CITY OF PORTLAND, MAINE

July 26th, 2011

Project Name: Harborview Townhomes
New building comprising 7 residential units
(19 space parking lot shared with existing 12 unit residential building)
Project ID: 2011-214
Project Address: 127 York Street (aka 121-129 York Street)
CBL: 44 - A-004/005

TO: Jean Fraser, Planner
FROM: David Senus, P.E. & Ashley Auger, E.I.T.
DATE: June 23, 2011
RE: Harborview Townhouses, Level III Final Site Plan Application

5 FENCE FROM NEIGHBOR'S PROPERTY
NOT TO SCALE

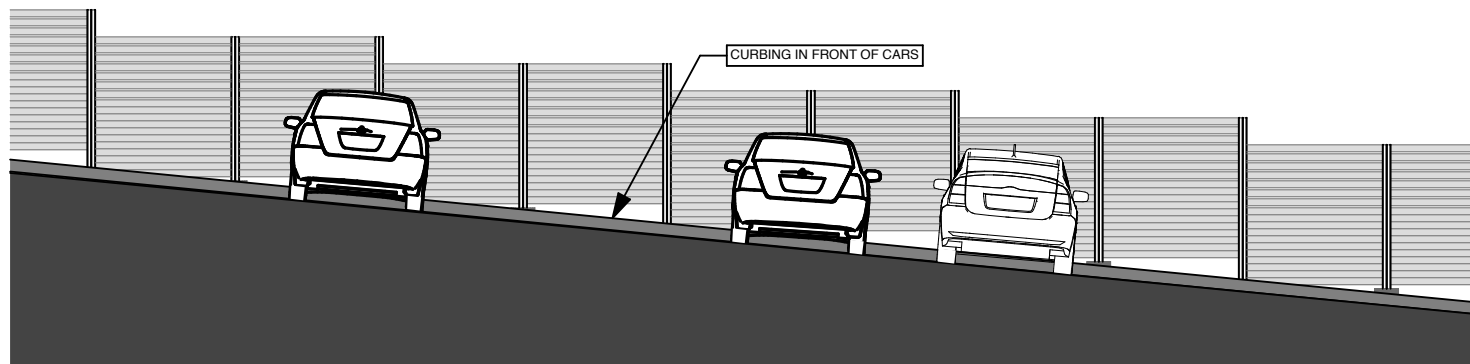
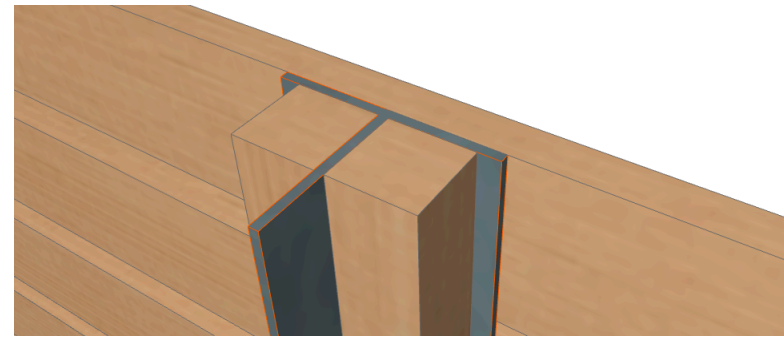
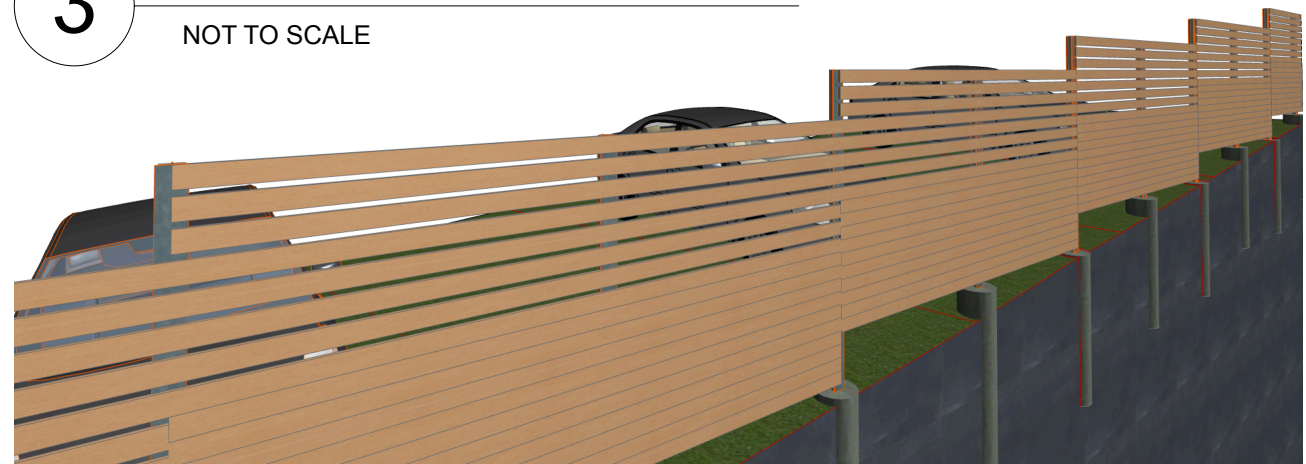
- i. That the applicant shall submit an example of the fence product proposed for the frontage of the property (or identify a location in the area where it can be seen) for review and approval by the Planning Authority prior to the issuance of a building permit; and

TITLE:  
**EXHIBIT A.**  
DIMENSIONED PARKING PLAN  
(NOT FOR CONSTRUCTION)

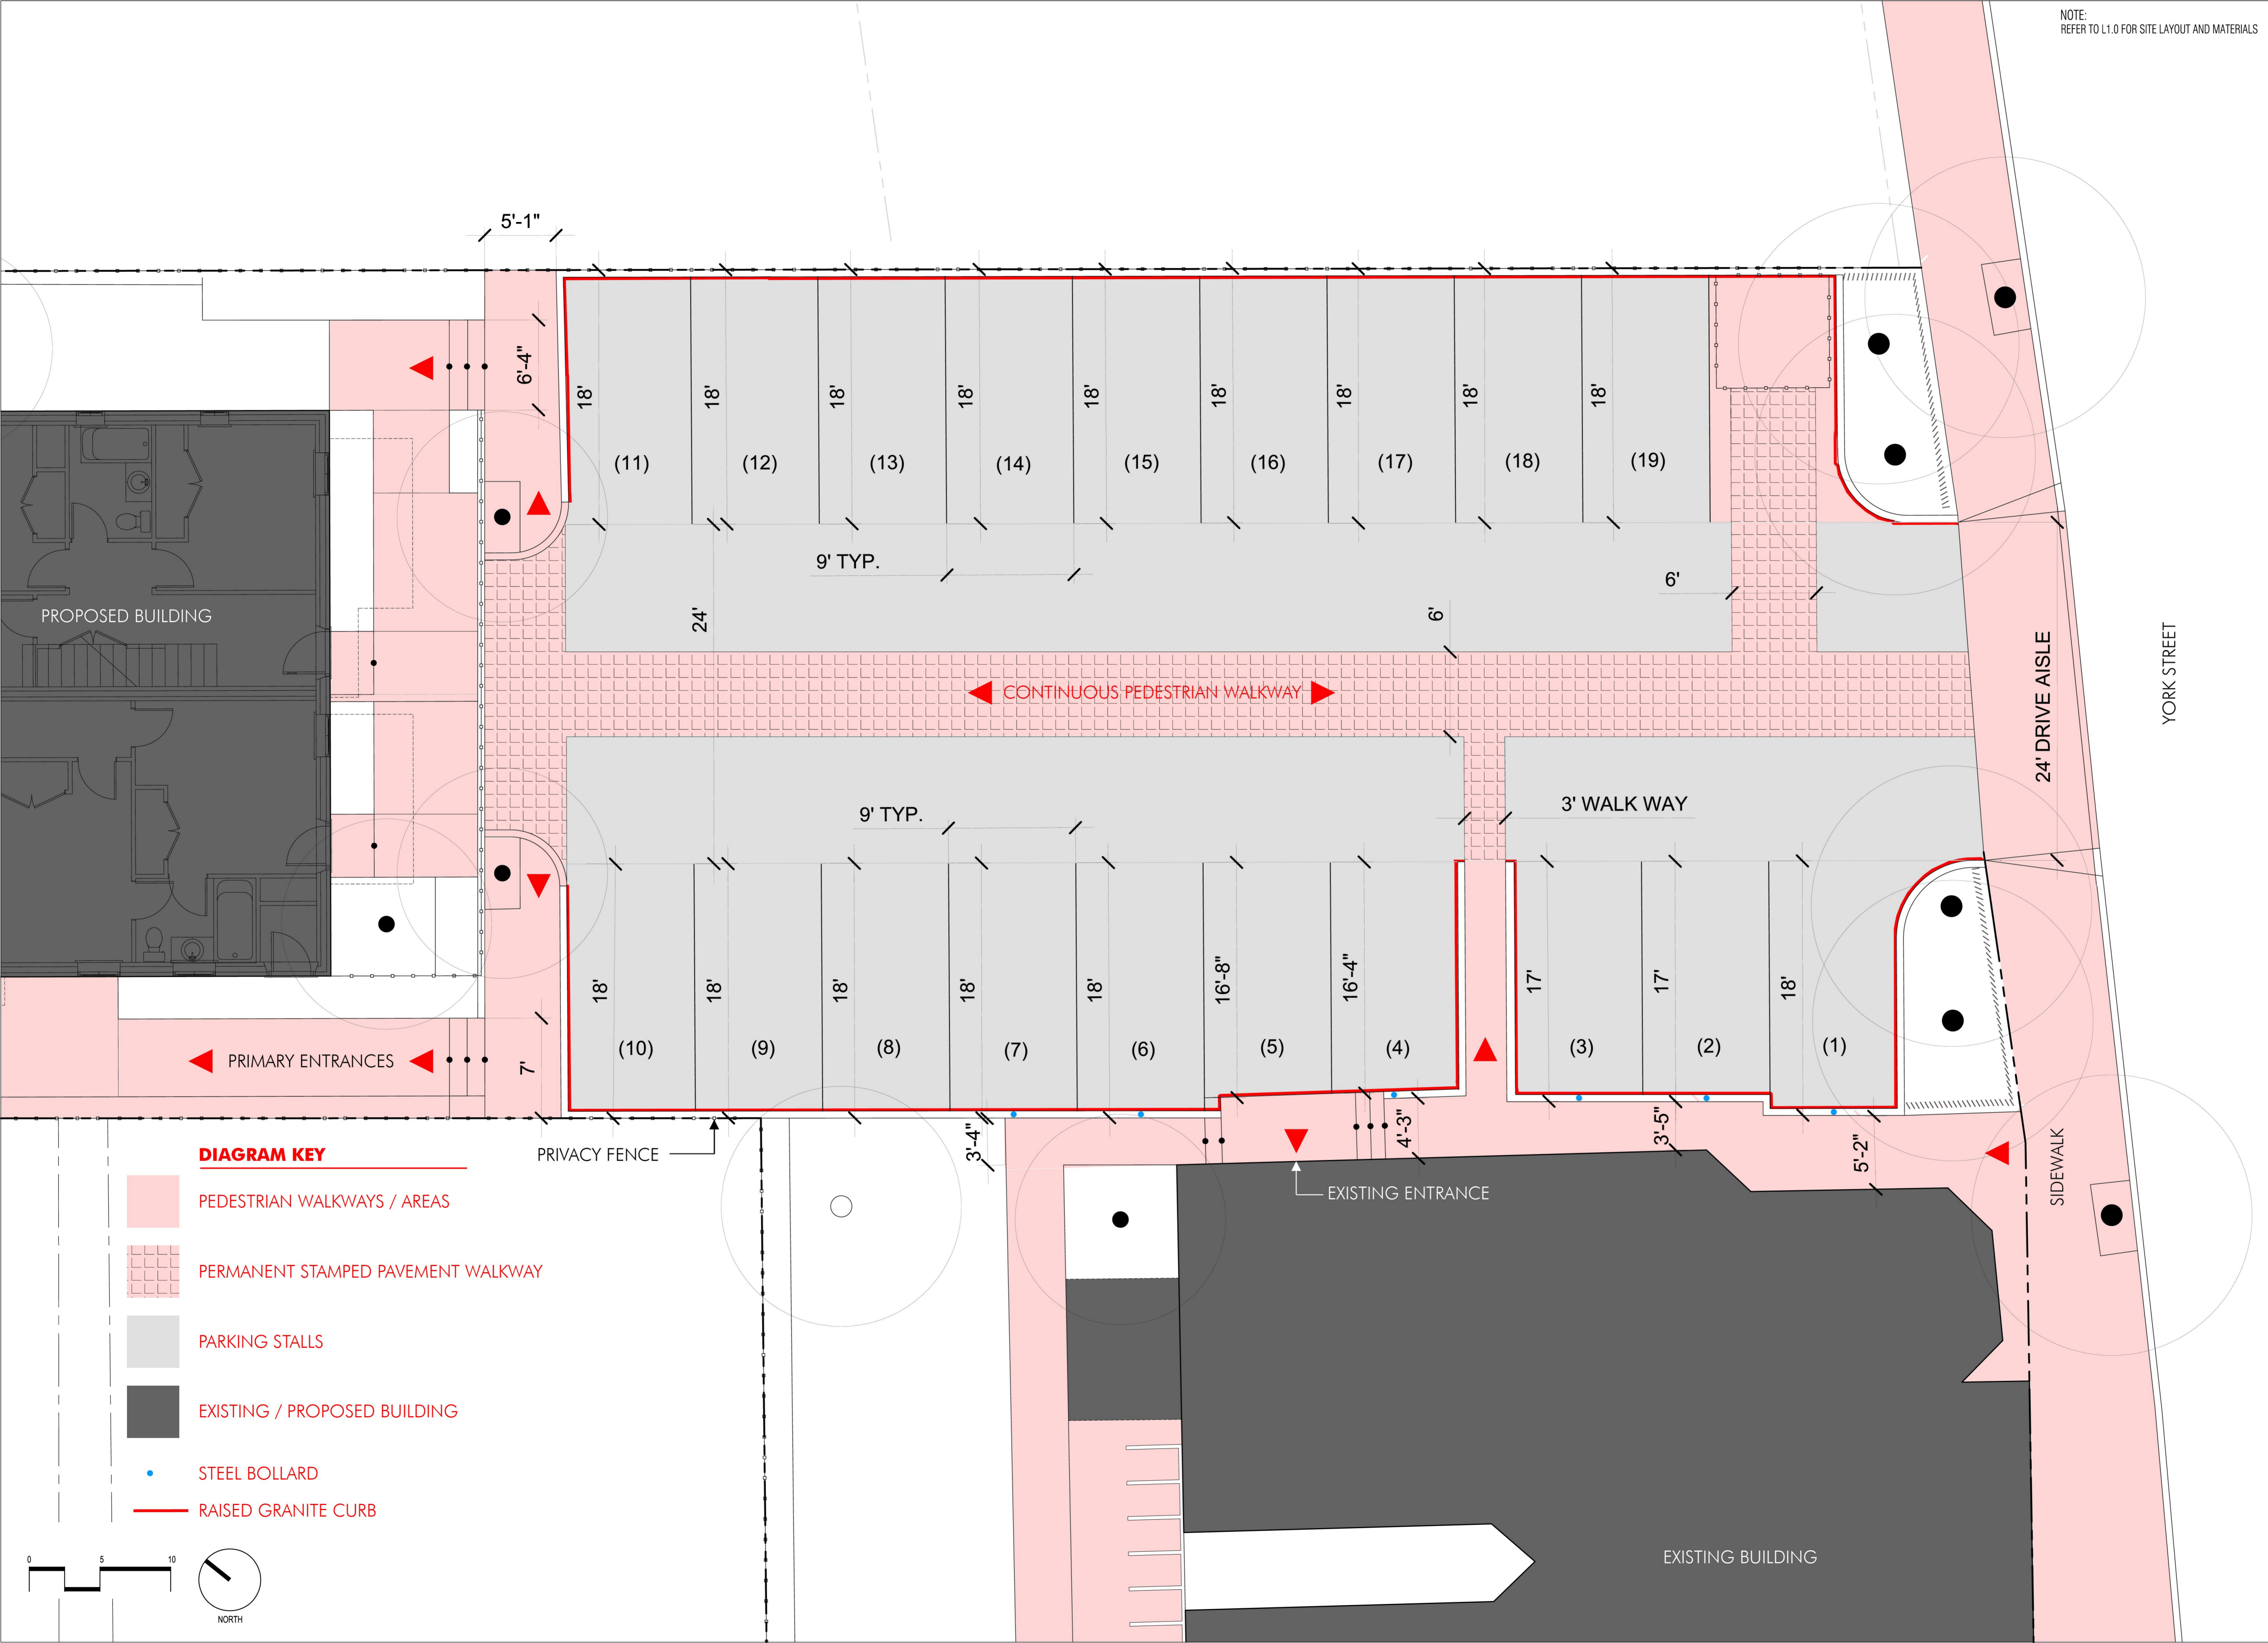
The Planning Board voted 6-0 (Morrissette absent) to waive Technical Standard, Section 1.14 to allow 4 of the 19 parking spaces to be compact parking spaces, as shown in the submitted plan "Exhibit A" (Attachment 4, page 4) dated 7.5.2011.

- ii. That the applicant shall submit revised site plans to incorporate the walkway route and associated revisions as shown in the submitted plan "Exhibit A" (Attachment 4, page 4) dated 7.5.2011, with the walkway section within the parking lot drive aisle to be a stamped pavement material of a different and visible color, for review and approval by the Planning Authority prior to the issuance of a building permit; and
